CITY OF ALBUQUERQUE

**RE: TR A-1 Plat of TRS A-1 & A-2 Sunport Municipal Addn. (M16D024C)
2200 Sunport Blvd. SE
Grading and Drainage Plan
Engineers Stamp Date 8/26/2022**

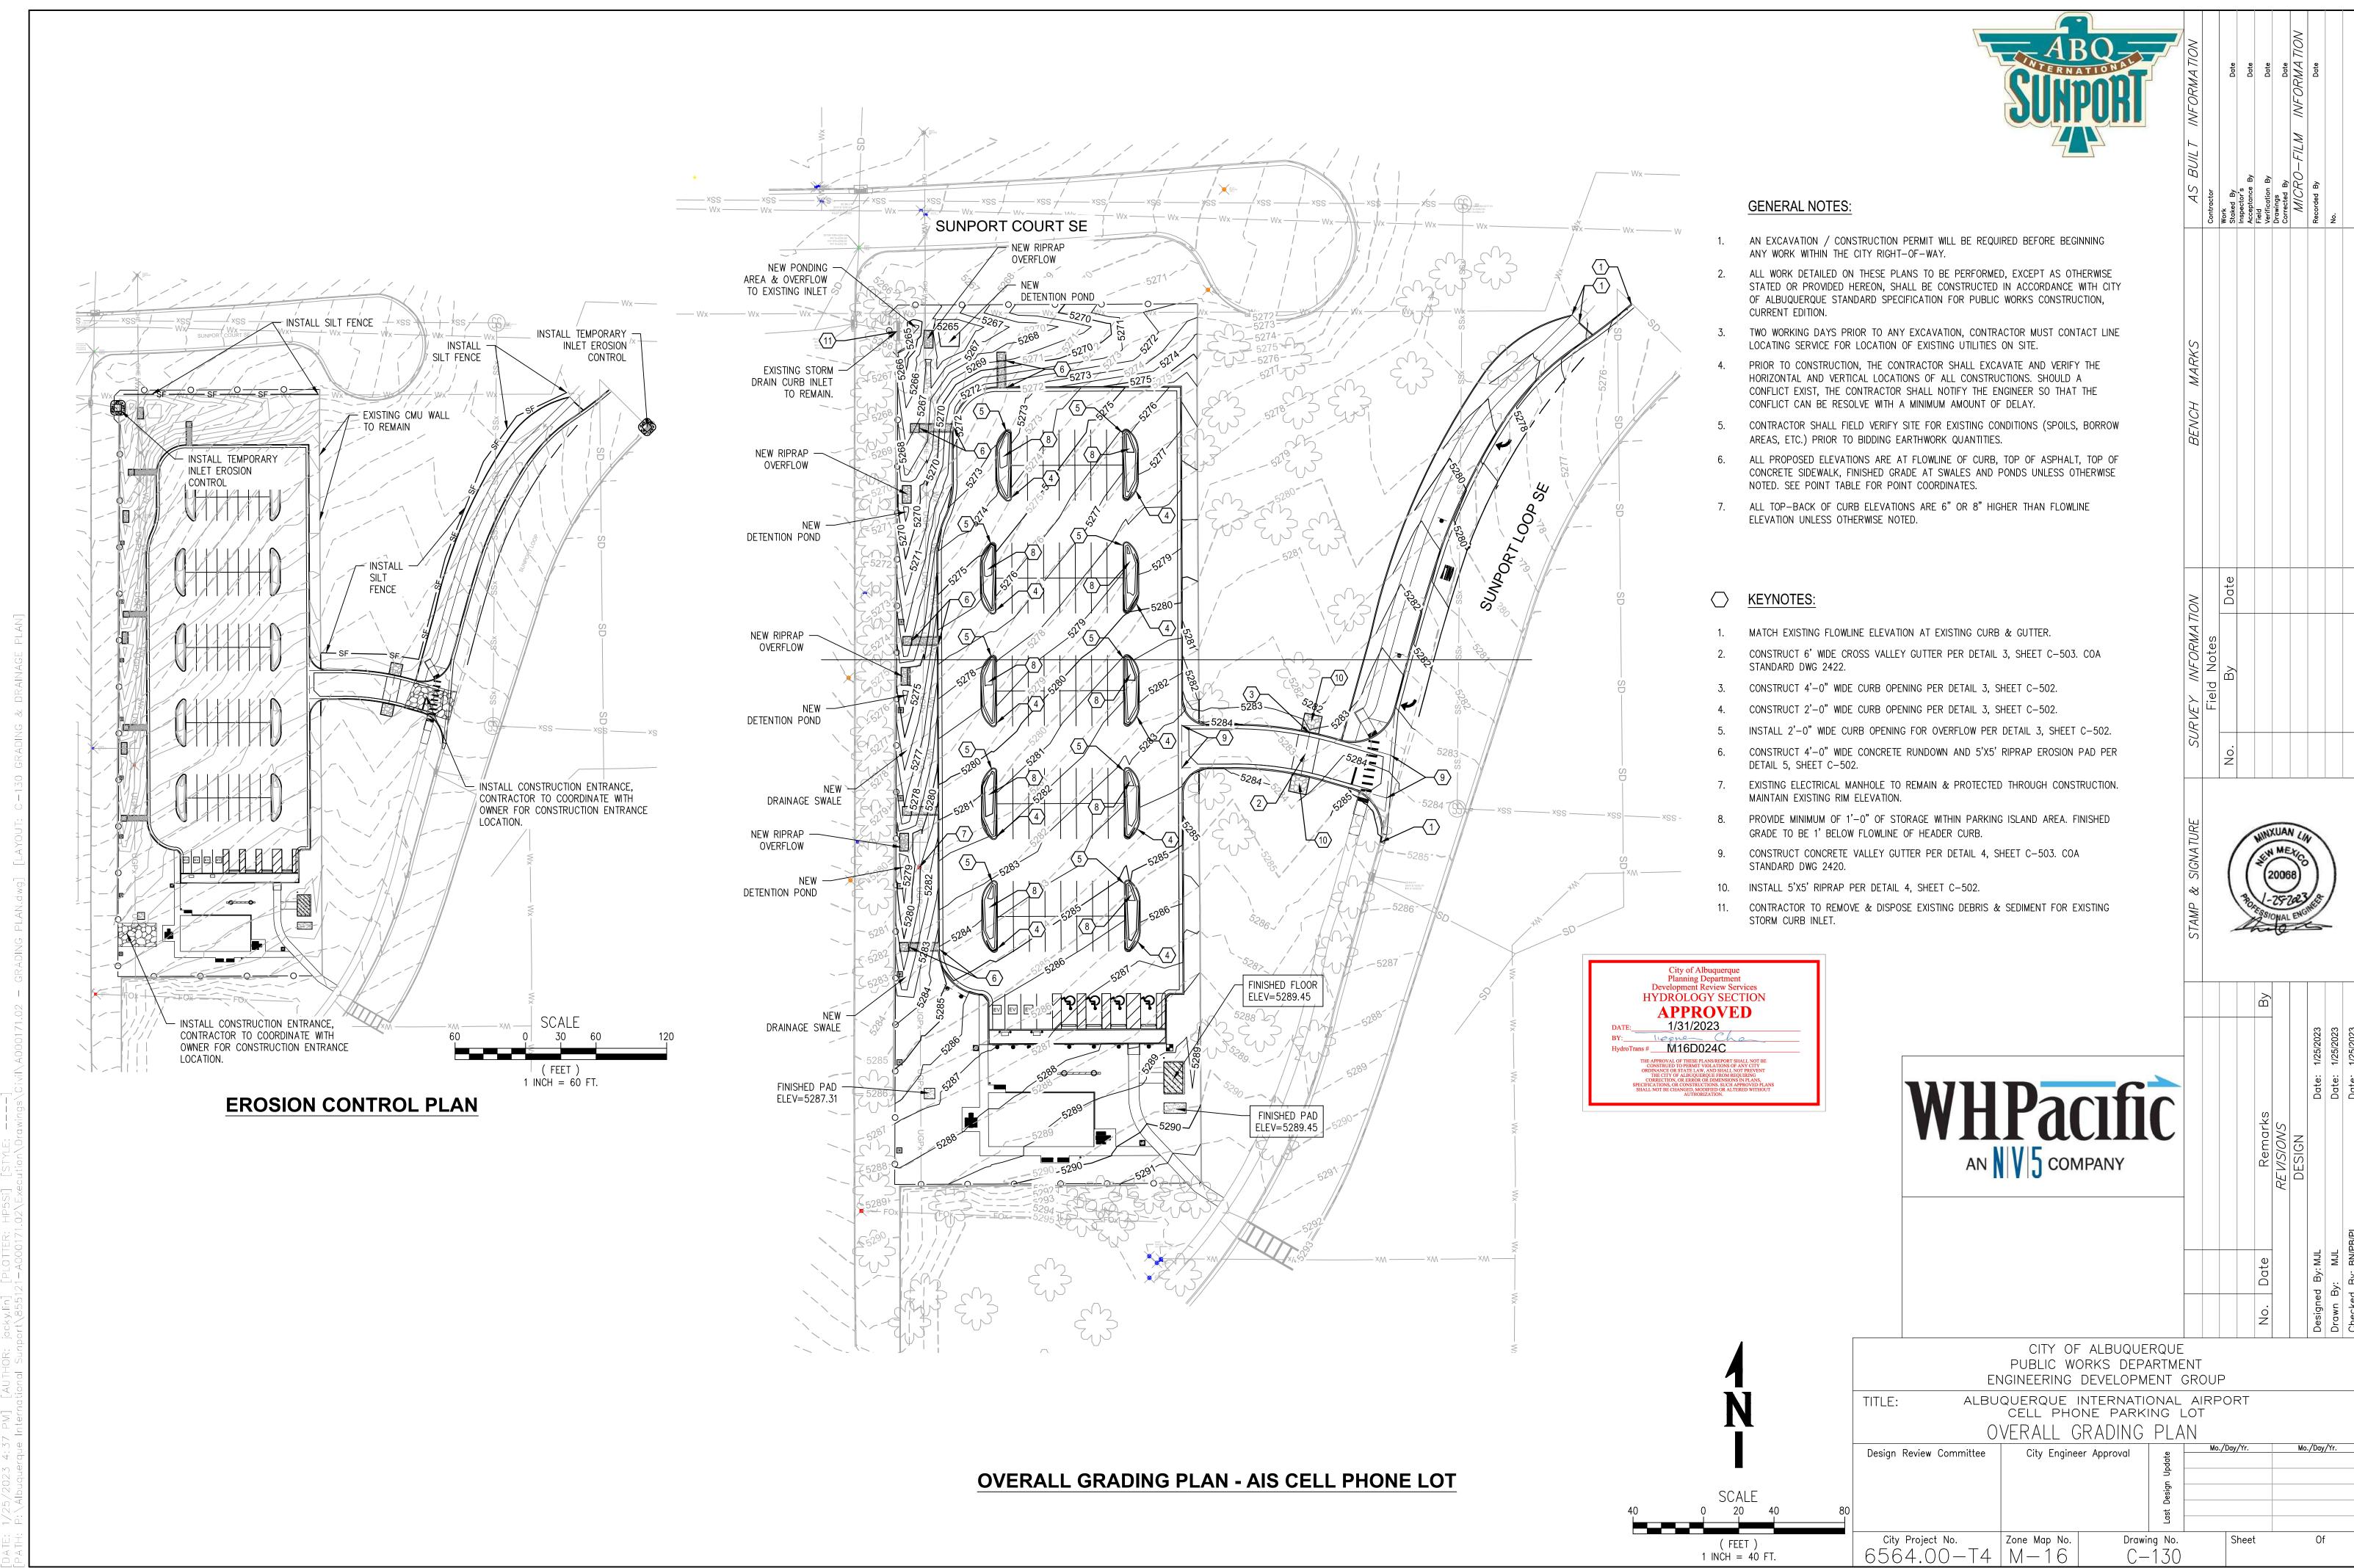
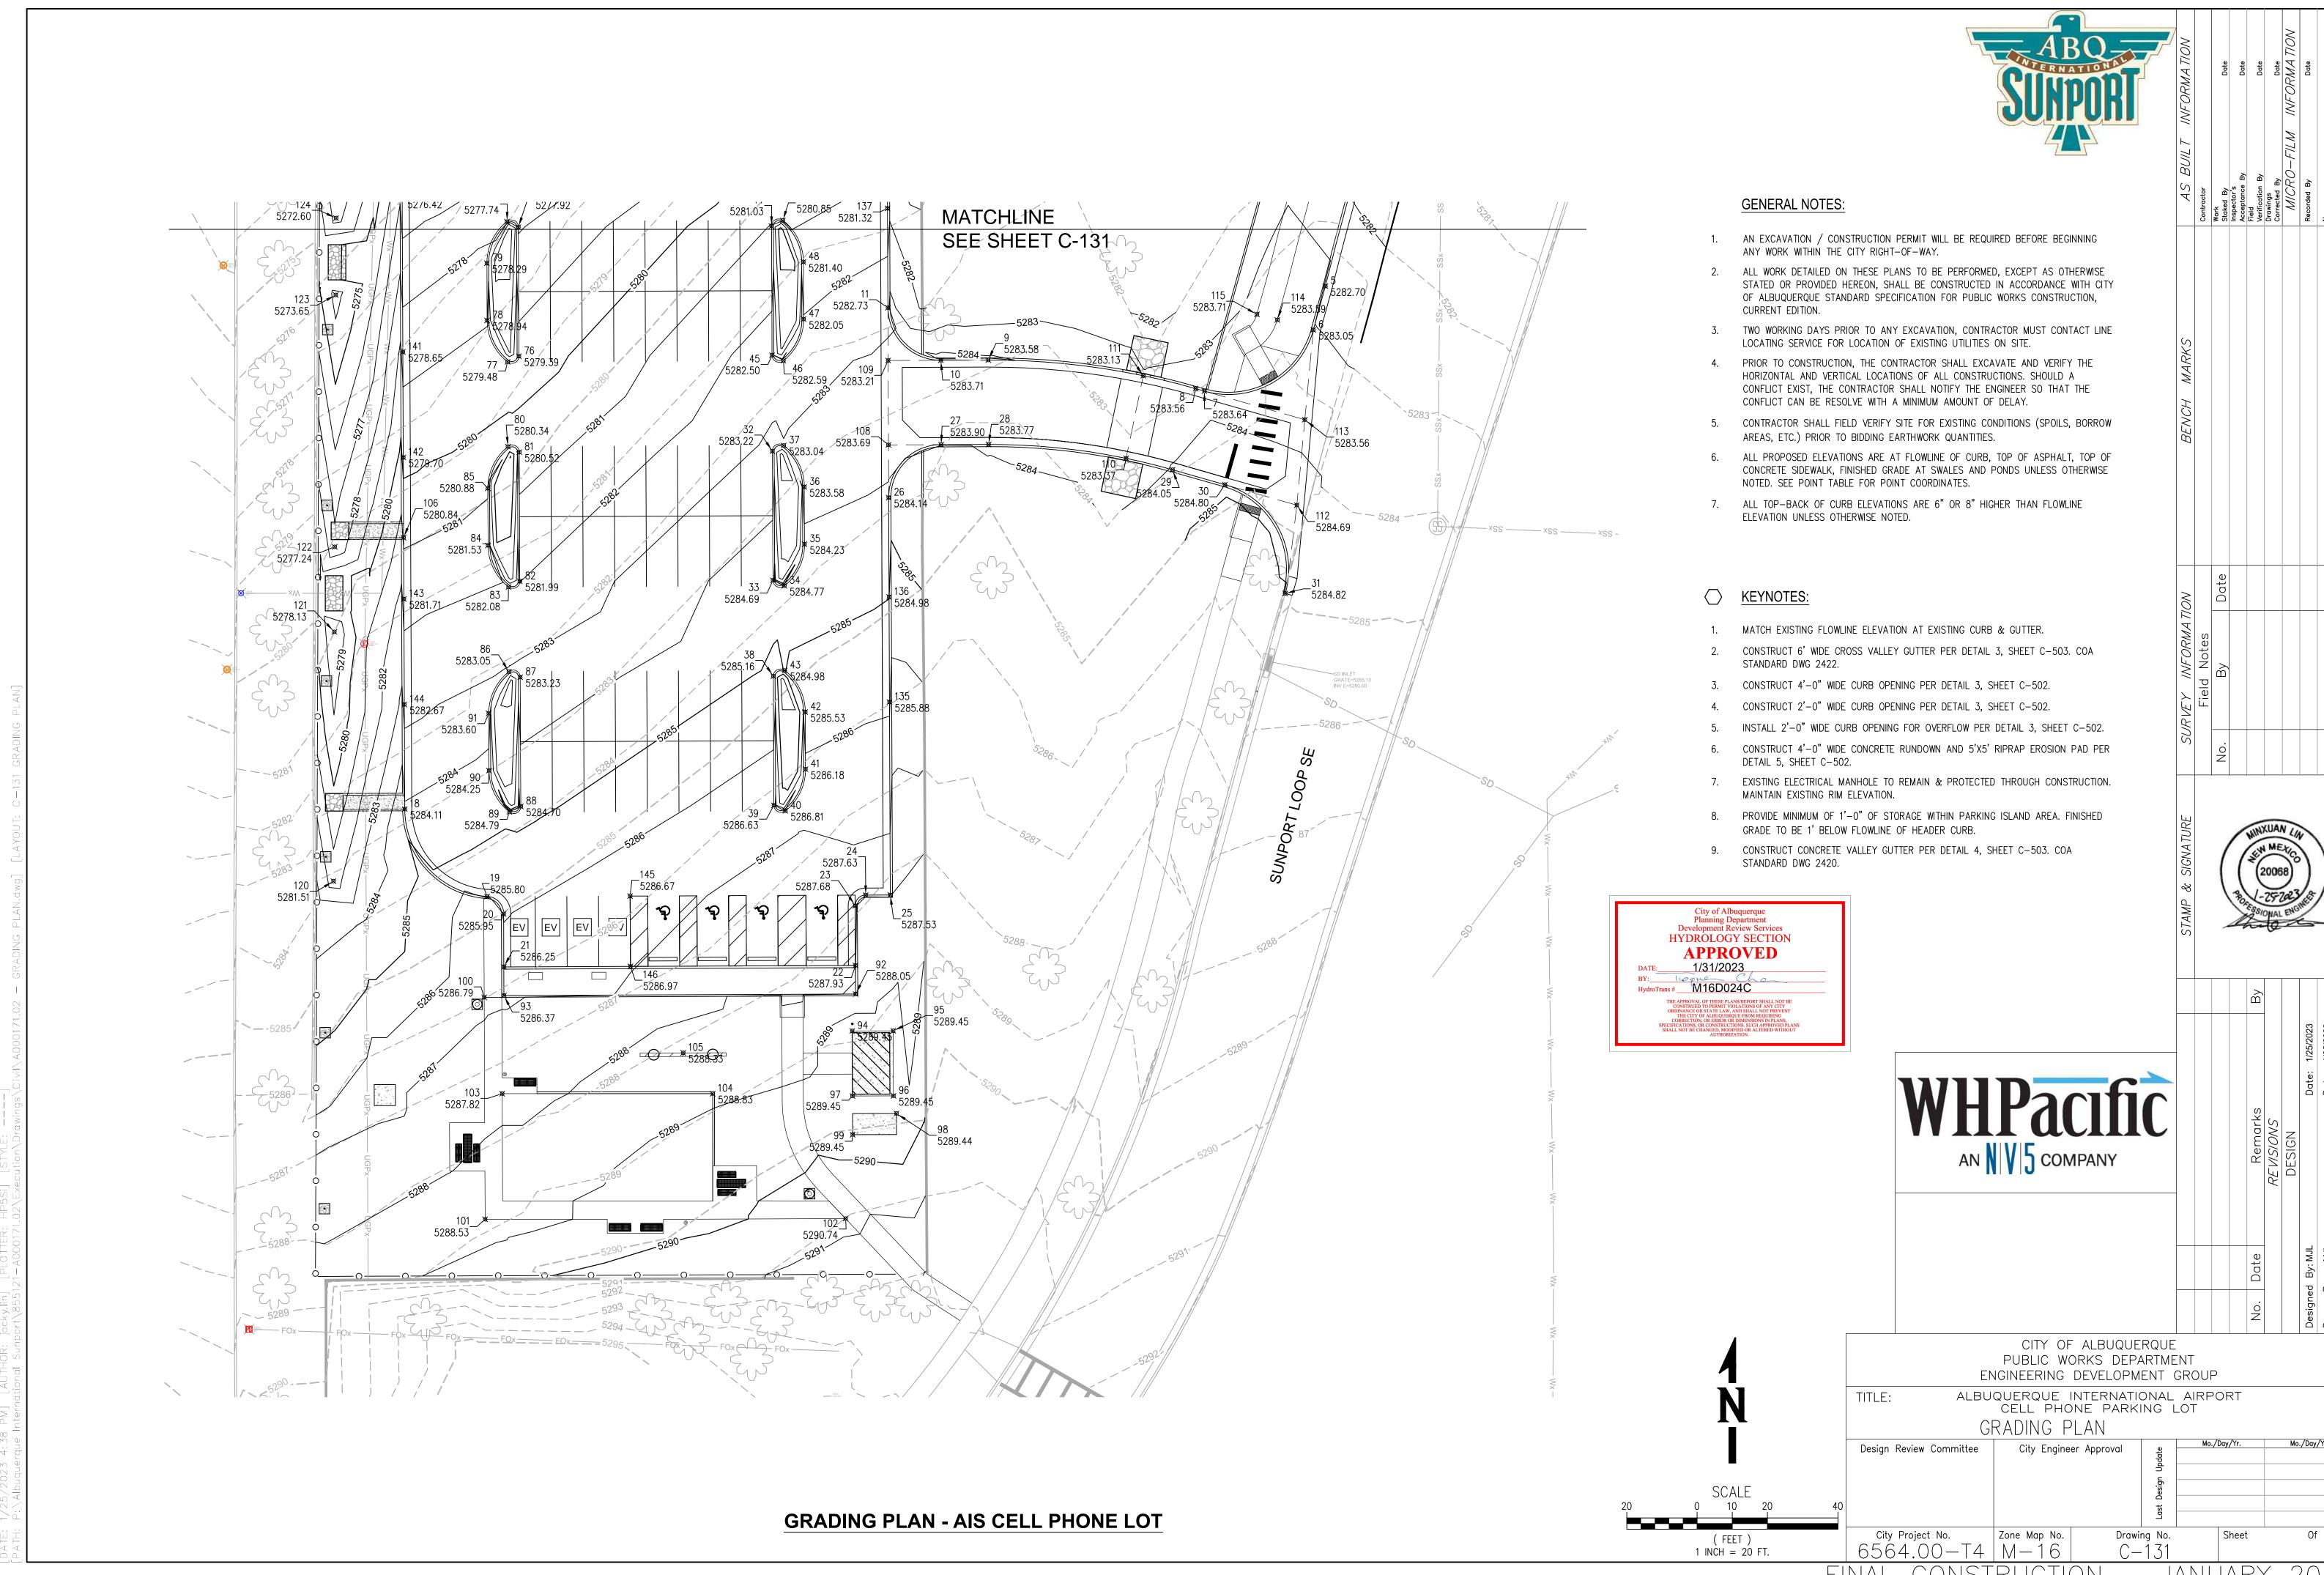
- 2) There is an existing area with buckled sidewalk just north of the start of deceleration lane.
- 3) There is an area were the runoff drains across the entrance. Please include riprap upstream of the low point as well.

- 5) Please provide more information about the existing inlet and provide inlet capacity calculations. Show spot elevations around the inlet to ensure runoff will not drain to the north instead of draining to the inlet. Please include a note that existing inlet to be cleaned (most likely full of sediment).

- 7) Was a Traffic Circulation layout submitted to Transportation for review and approvals?
- 8) Provide Finished Floor elevation for the restroom pad.
